HS2 Response to comments from Historic England (GLAAS)

West Ruislip Golf Course (Ref: 10737/APP/2020/3359)

Figure 7. Location of extant and levelled Ridge and Furrow

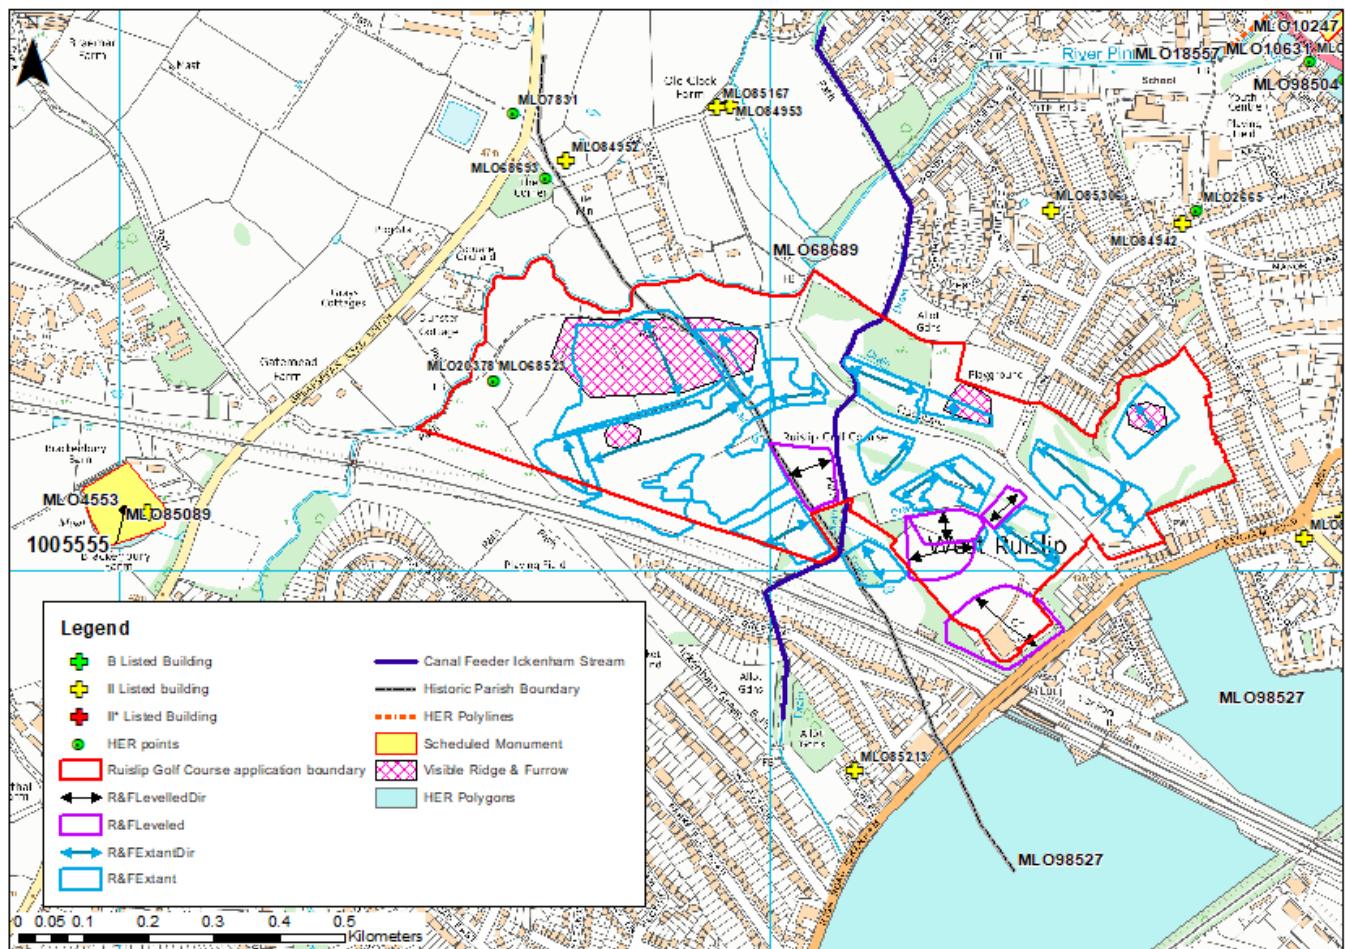
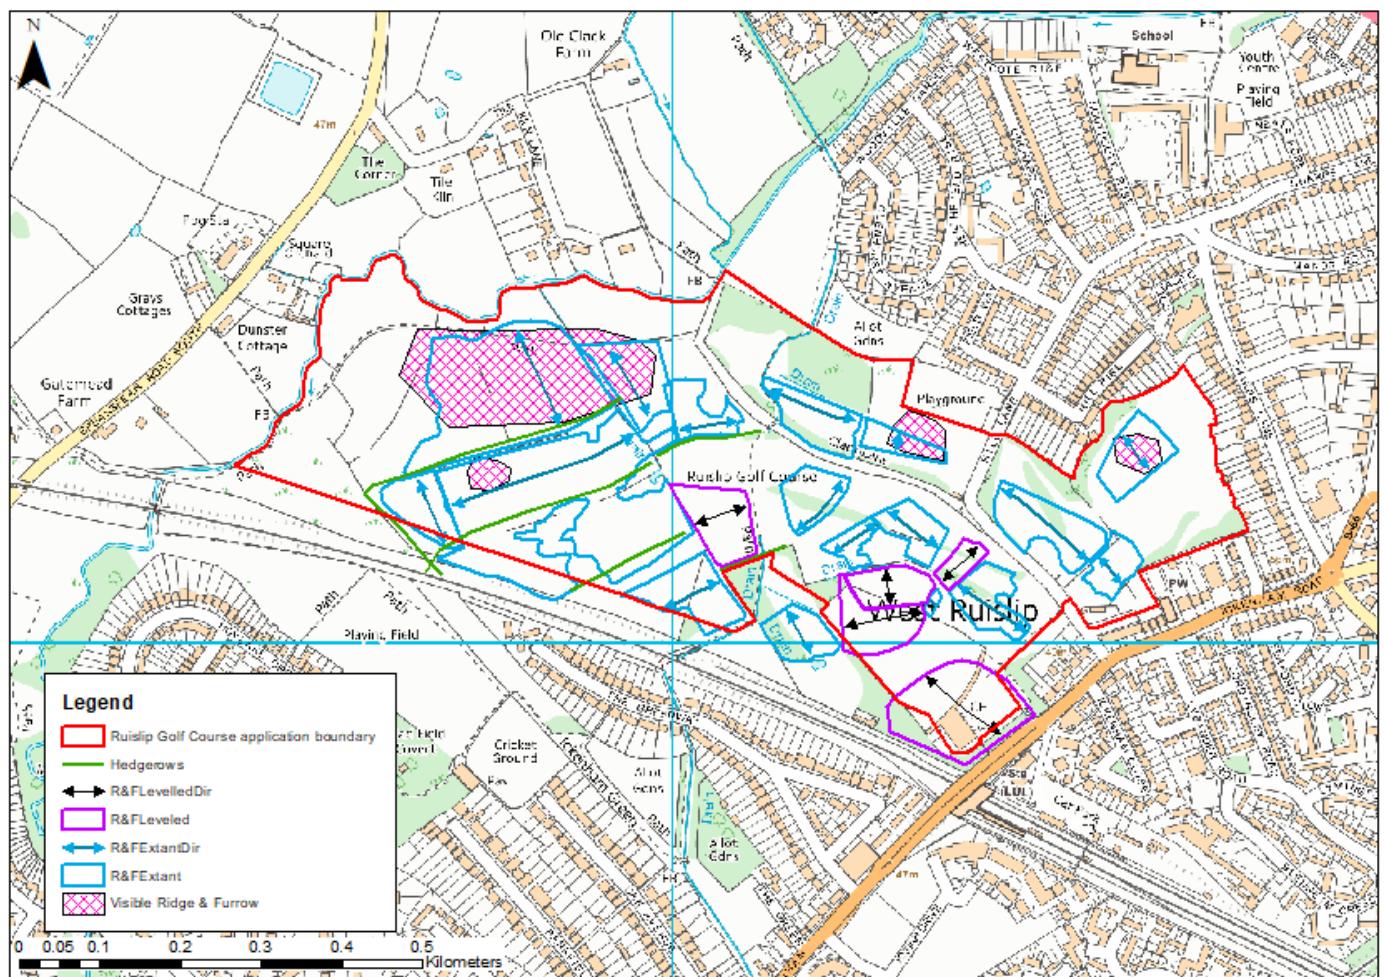
The extensive earthworks and drainage could cause serious harm or complete loss of buried archaeological remains as well as causing minor loss of ridge and furrow. Accordingly, additional studies set out below are advised:	
Evaluation: An archaeological field evaluation involves exploratory fieldwork to determine if significant remains are present on a site and, if so, to define their character, extent, quality and preservation. Field evaluation may involve one or more techniques depending on the nature of the site and its archaeological potential. This report will usually be used to inform a planning decision but can also be required by condition to refine a mitigation strategy after permission has been granted. In this case what is needed is submission of a report on the field evaluation trenching already carried out within and adjacent to the golf course and a review of its implications in relation to the site's archaeological potential and appropriate mitigation. Public engagement in archaeological investigations in this accessible location should be sought if significant remains are found.	Accepted: evaluation and mitigation proposals are currently being developed. Reports will be submitted to GLAAS as part of a planning condition which will include the final details of this evaluation/mitigation strategy. Please see the comment above for further details on public engagement.
